Recommendation Report for Planning Permission for Works or Extension to a Dwelling

REF NO: EP/104/25/HH

LOCATION: 7 North Lane
East Preston
BN16 1BN

PROPOSAL: Self contained car port.

Site Plan - Proposed
0m 5m 10m 15m 20m
1:500 Scale bar

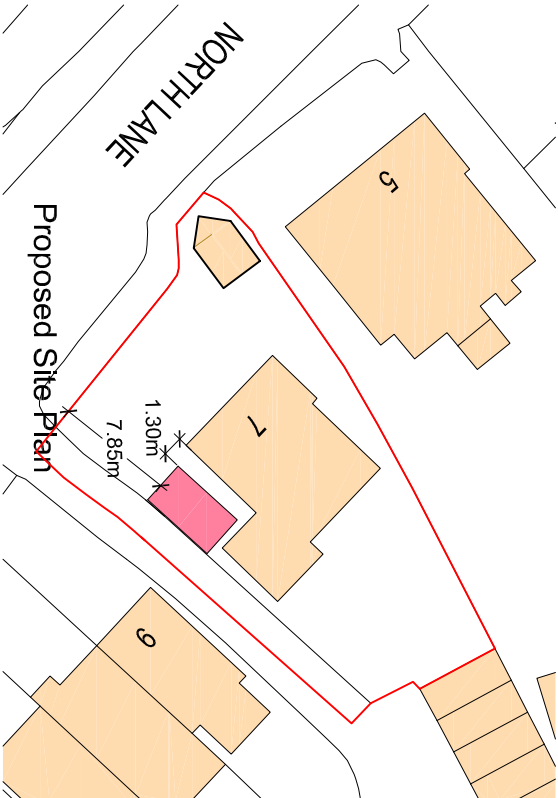
The proposal seeks permission for the construction of a self contained car port to the front/side of the dwelling. The car port would measure approximately 3m in width and 5.3m in depth and would be positioned adjacent to the south eastern side boundary, with a separation distance of approximately 1.3m from the host dwelling.

Although the car port would be minimally set back from the principal elevation of the host dwelling, contrary to Section M of the Arun Design Guide, this minor deviation would not result in any harm to the character or visual appearance of the property.

Due to its sitting, the proposal would be visible within the street scene. However, given its modest scale, sympathetic design, and the existing site context, which includes an outbuilding and a mature tree, the proposal would not appear unduly prominent or visually intrusive. The development would not adversely affect the character or appearance of the surrounding area and would be finished in materials that match or closely resemble those of the host dwelling, in accordance with policy D DM1 of the ALP.

The proposed car port would be located to the south east of the host dwelling and set back 7.8m from the highway. The nearest neighbouring property is situated to the south east at a distance of approximately 4m, separated from the application site by an access road. Given the spacing maintained between the car port and the neighbour to the south east, the proposal would not result in overbearing or overshadowing impacts to this neighbour.

Notwithstanding this, sufficient parking is available within the forecourt of the property to accommodate at least three vehicles. As such, the proposal would continue to comply with the parking requirements set out in the Arun Parking Standards.

FLOOR PLAN

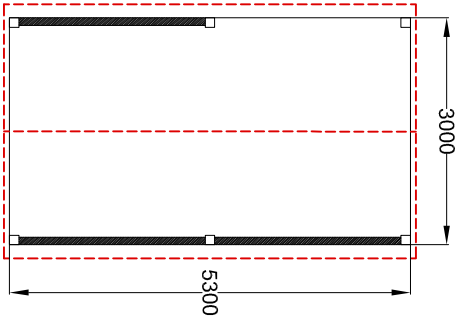
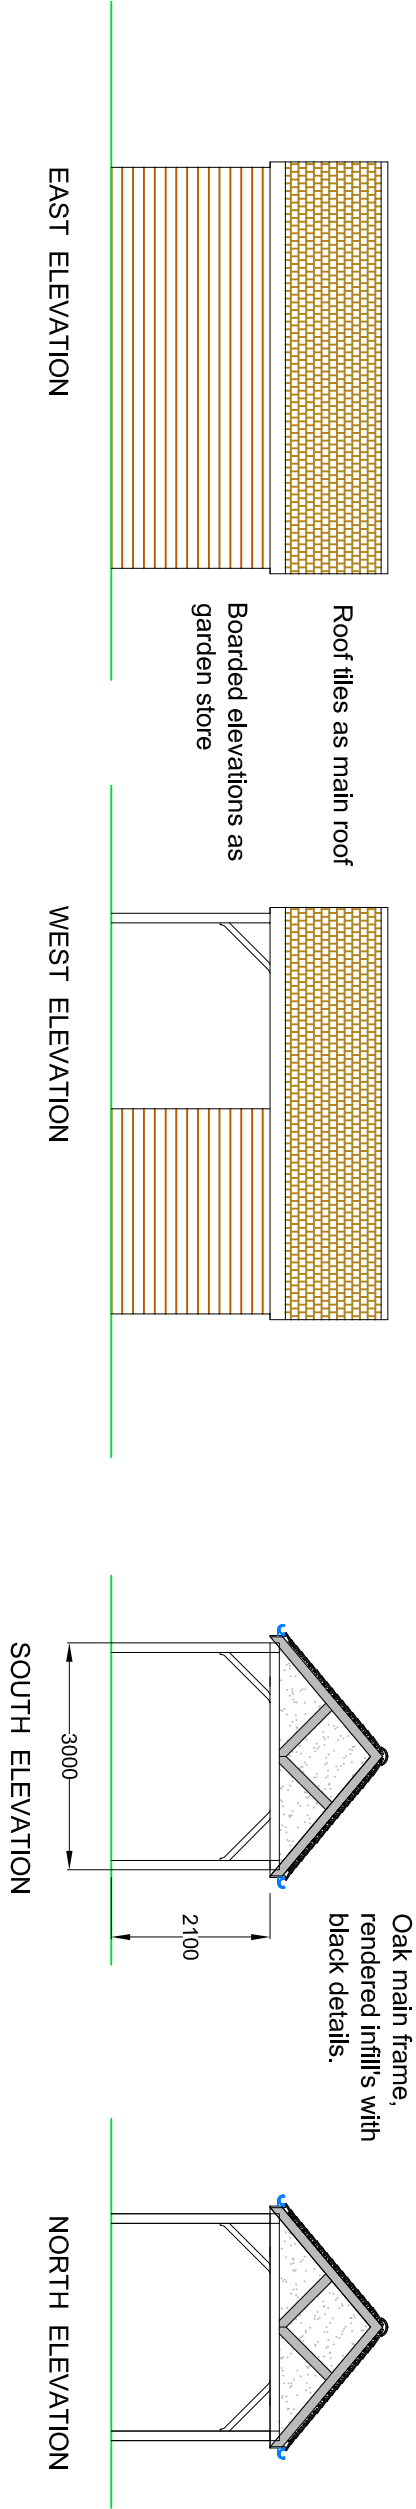
The proposed structure would have a maximum roof height of 3.6m and an eaves height of 2.1m. It would incorporate a pitched roof form finished in clay tiles to match the host dwelling, together with an oak frame and black infill detailing to reflect the appearance of the existing dwelling. The side elevations would be finished in timber boarding, similar in appearance to the existing outbuilding. These design features would ensure the proposal is visually cohesive and well integrated with the host dwelling.

The southern elevation of the proposal would remain open to facilitate vehicle access and would overlook the front amenity space of the host dwelling. The proposed car port would not give rise to overlooking of neighbouring properties and would therefore not result in any loss of privacy. Overall, the proposal would not cause harm to neighbouring residential amenity in terms of overbearing, overshadowing, or overlooking. The development is therefore in accordance with Arun Local Plan policy D DM1 and the Arun Design Guide (ADG).

five bedroom dwelling is required to provide three parking spaces. It is noted that the proposed car port would not meet the best practice minimum internal dimensions for garages or car ports. The ADG states that parking spaces should measure at least 6m by 3m internally in order to qualify as a parking space.
